From: Holmstrom, Rick <HolmstR@wsdot.wa.gov>
Sent: Thursday, June 06, 2013 12:54 PM
To: Christina Wollman; Jeff Watson
Cc: Gonseth, Paul; Kaiser, Mark; rg98926@yahoo.com
Subject: RE: notcho lane

Christina/Jeff-there has been an interpretation that the easement provided to Probasco under AF426164 for the access easement on Notcho lane is a “non-exclusive” easement. As such, the concerns we raised in our comment letter dated May 21, 2013, have been addressed. WSDOT does not require anything further regarding this BLA.

BL-13-00007

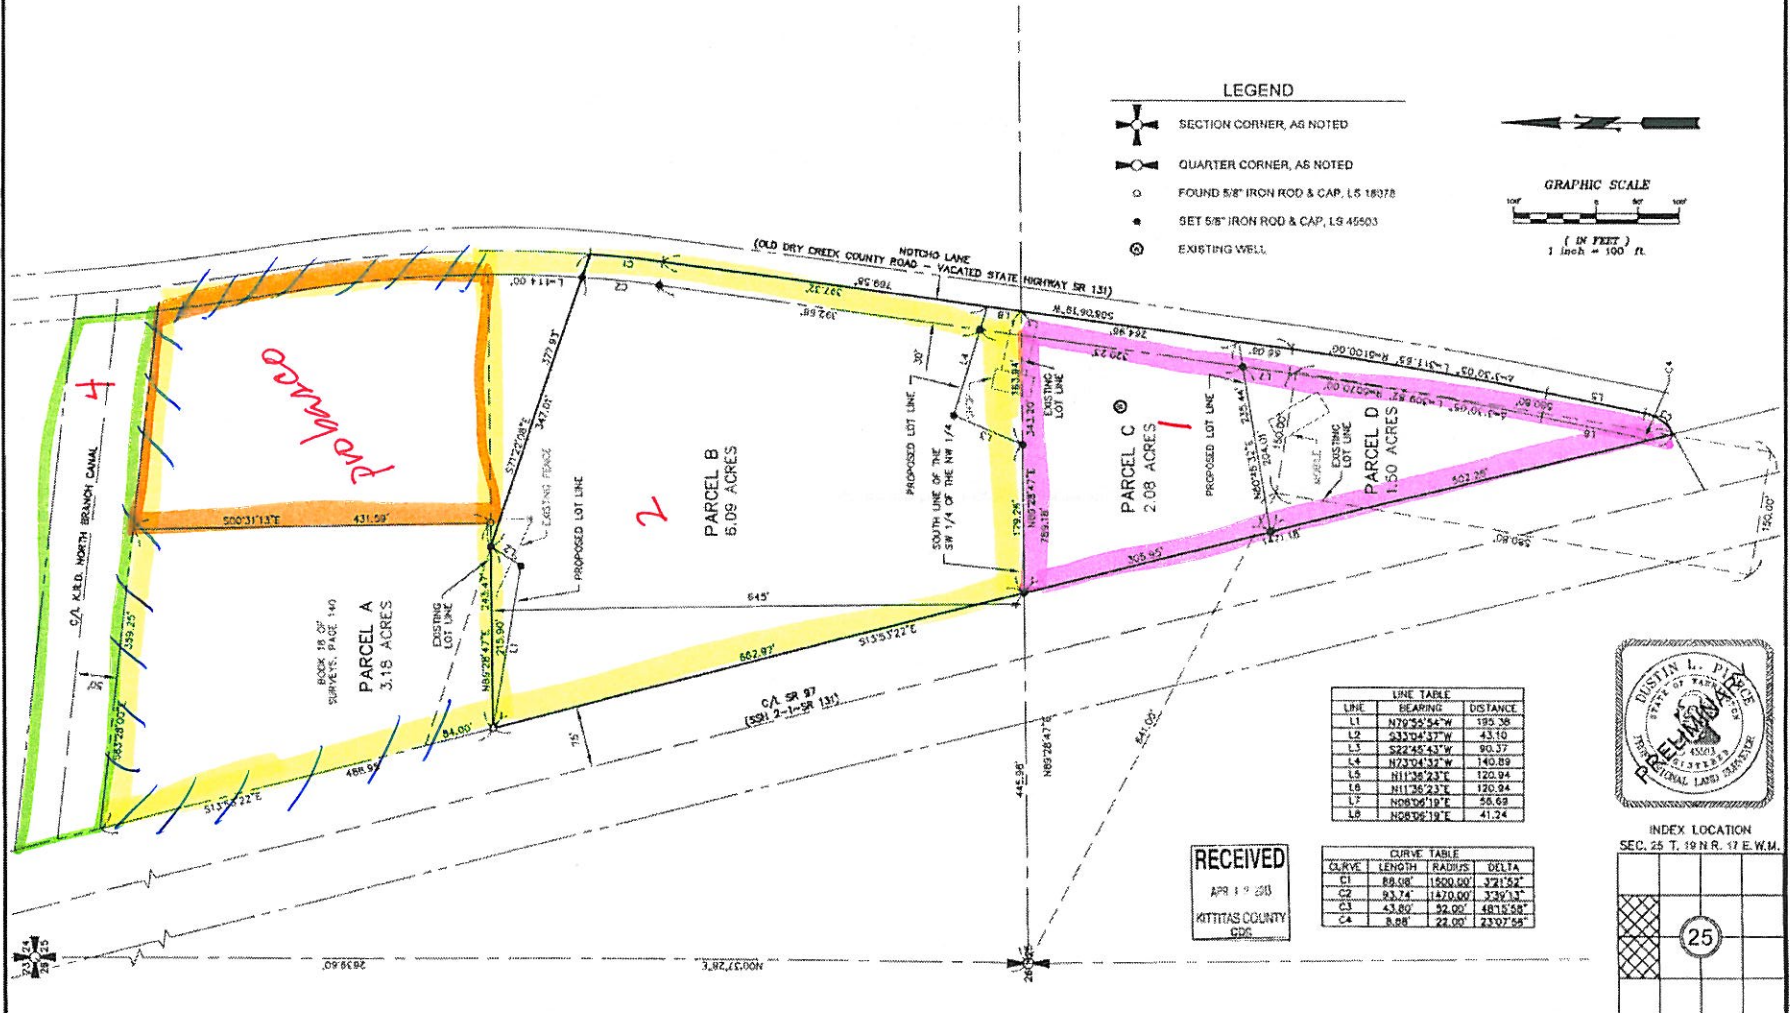
Does your requirement include parcel A? It does not have frontage on Notcho Lane.

Christina-thank you. The document (access easement) you have attached does provide access from the southern US97/Notcho Lane to then Probasco (now Lee) parcel. That is good for our records.

That said, we require a similar easement be extended from Notcho, to address all parcels of the BLA.

The requirement is based on WAC 468-52-040.
